WEST SUSSEX COUNTY COUNCIL CONSULTATION

TO:	Arun District Council FAO: Amber Willard
FROM:	WSSC – Highway Authority
DATE:	18 March 2026
LOCATION:	Land East Of The Croft Surgery Barnham Road Eastergate PO20 3RP
SUBJECT:	BN/10/26/PL Approval of details reserved by condition under BN/38/24/PL relating to conditions 5, 7, 16, 19, 20, 21, 22, 23 & 24. (See Application BN/12/26/DOC for conditions 8 & 9 - drainage). Additional plans received.
DATE OF SITE VISIT:	n/a (desktop study undertaken for purposes of this planning application)
RECOMMENDATION:	Advice

This is the **second** WSSC Highways response to the above planning application seeking approval of details reserved by condition under BN/38/24/PL relating to conditions 5, 7, 16, 19, 20, 21, 22, 23 & 24.

Comments below specifically respond to highways-related condition 16 (secure and covered cycle parking).

Description:
EXTERNAL WORKS Sh12

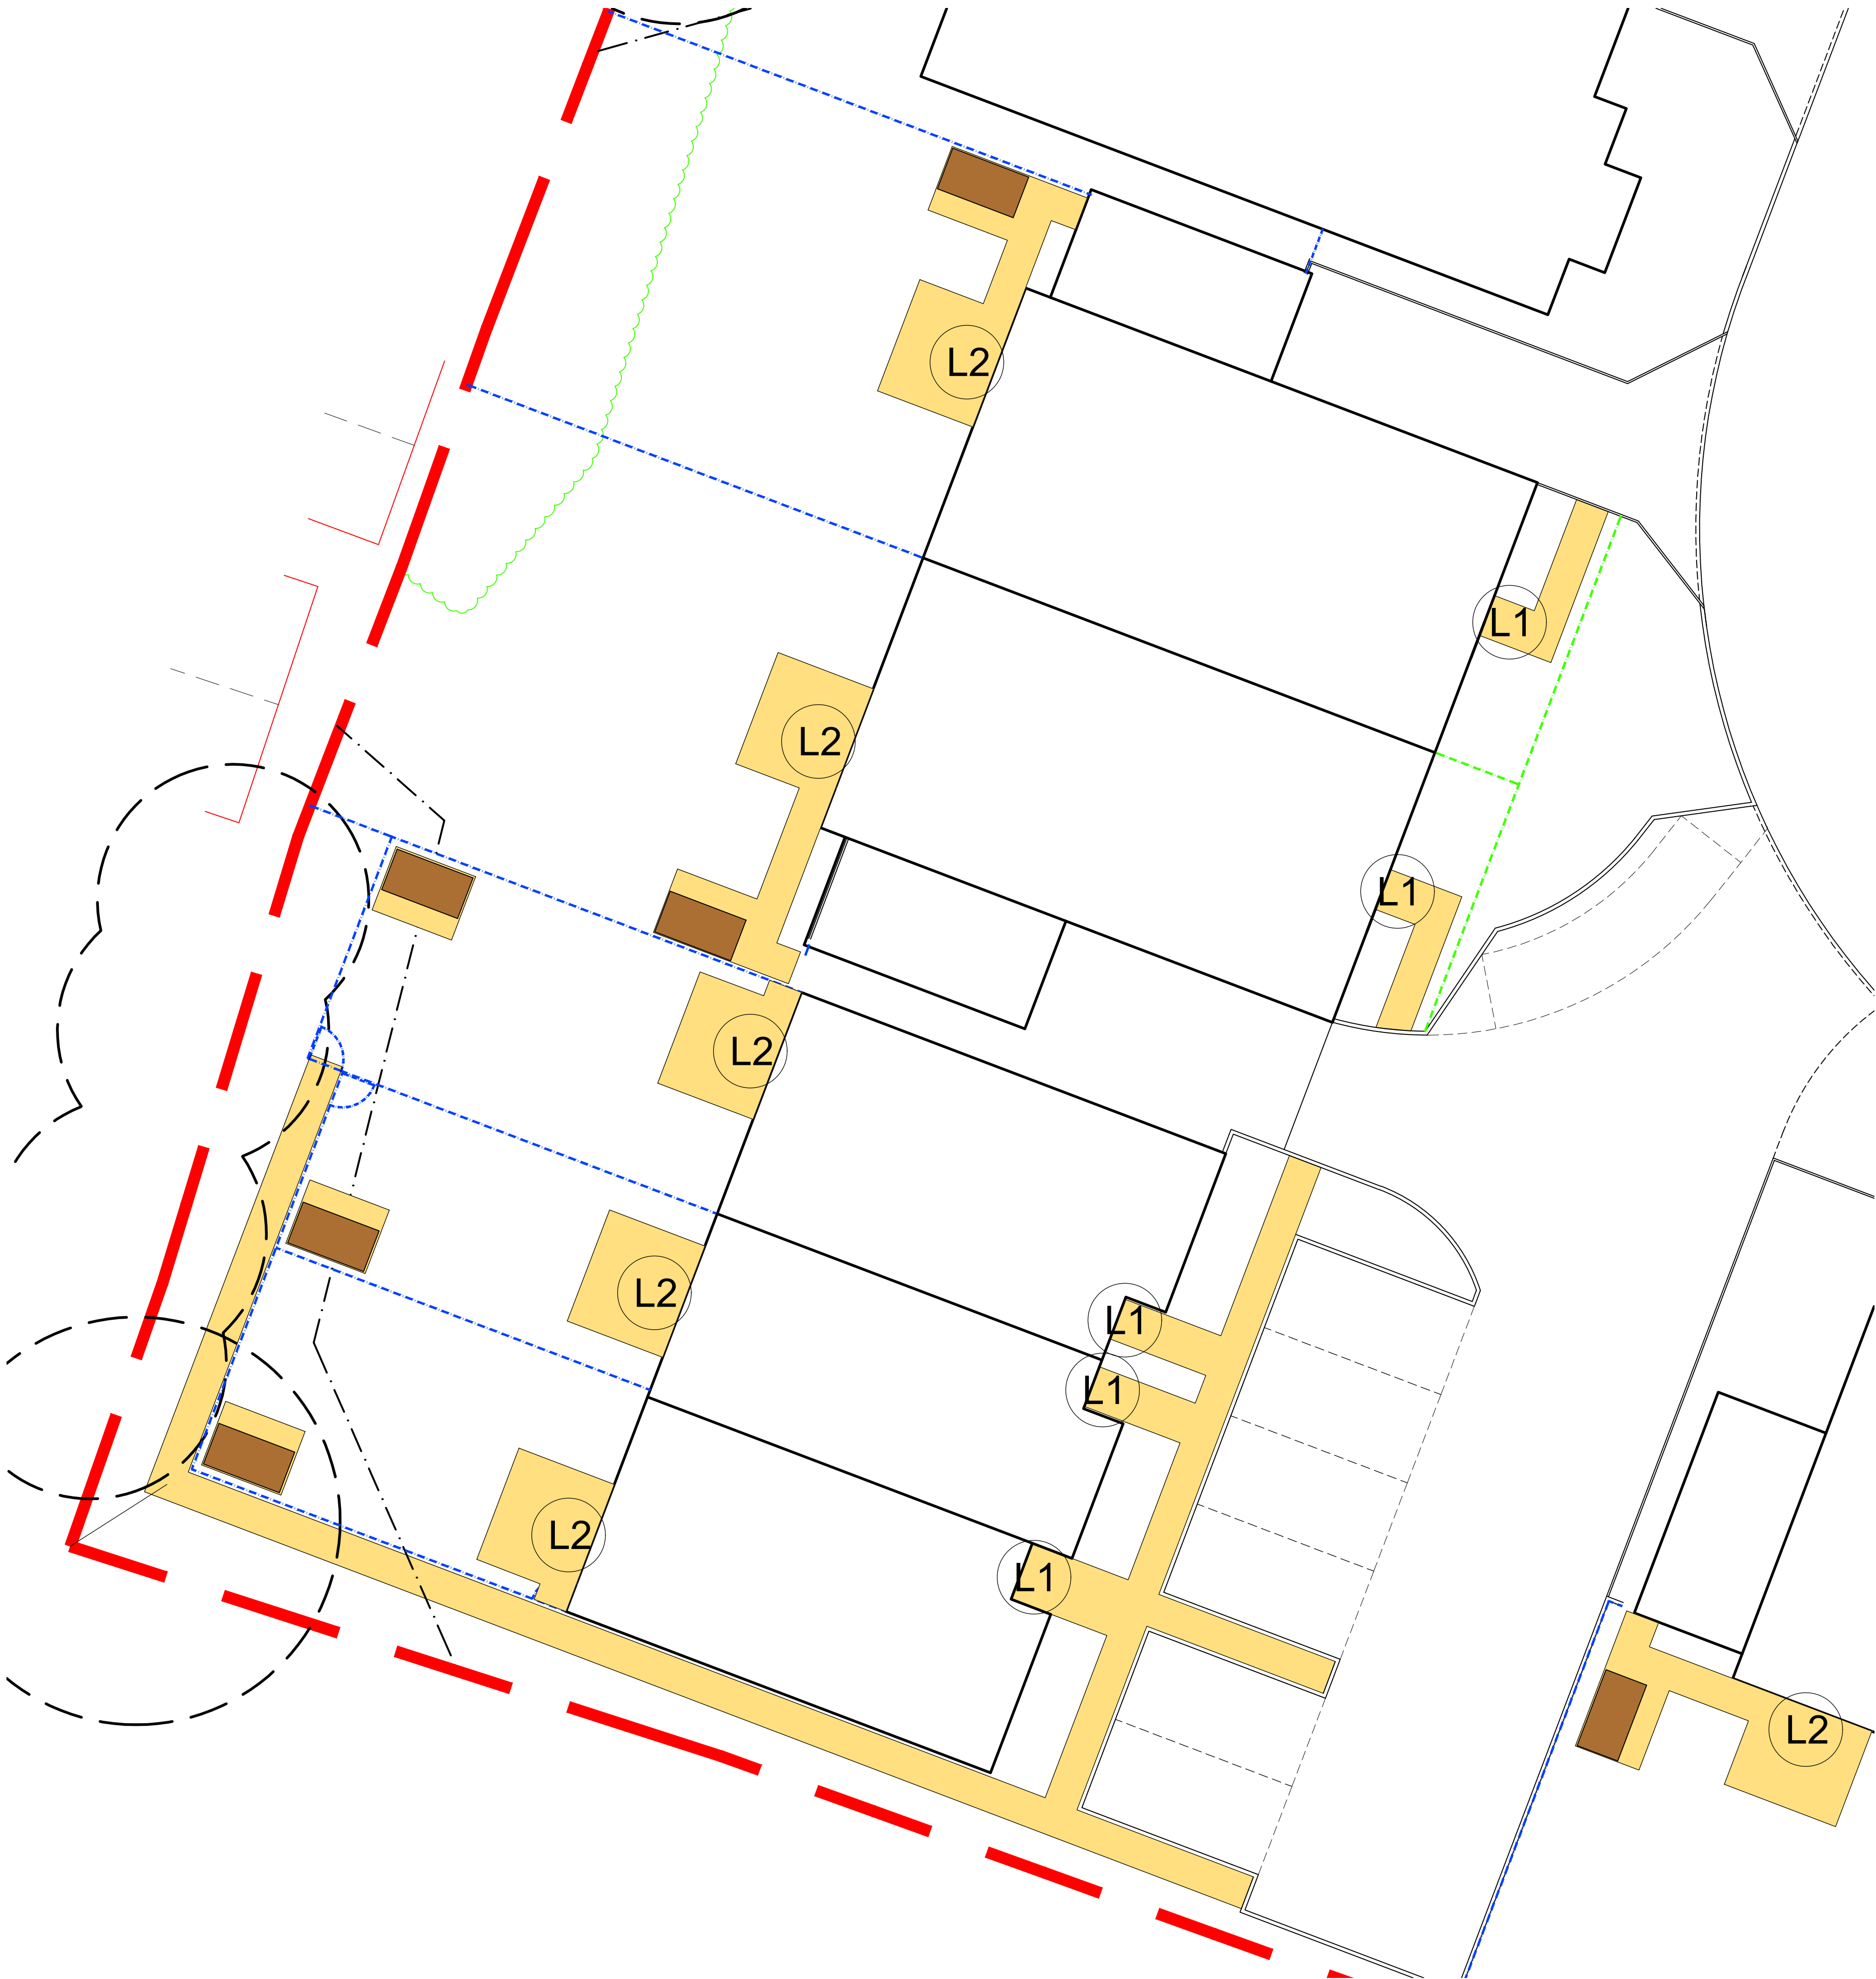
- (1)** The following extracts, taken from the external works plans, show the plots where it is not clear how access to the bicycle storage will be achieved from the access road. Applicant to provide details, please.

(2) And for the following (overleaf), no cycle storage is shown. Applicant to amend, please.

Drawing Number 2645-TFC-XX-00-DR-L-1001, revision P02, produced by Terrafirma Landscape Architects, now shows how cycle storage for each dwelling will be accessed.

This is also now shown (within garages) on Drawing Number 2645-TFC-XX-00-DR-L-1001, revision P02, produced by Terrafirma Landscape Architects.
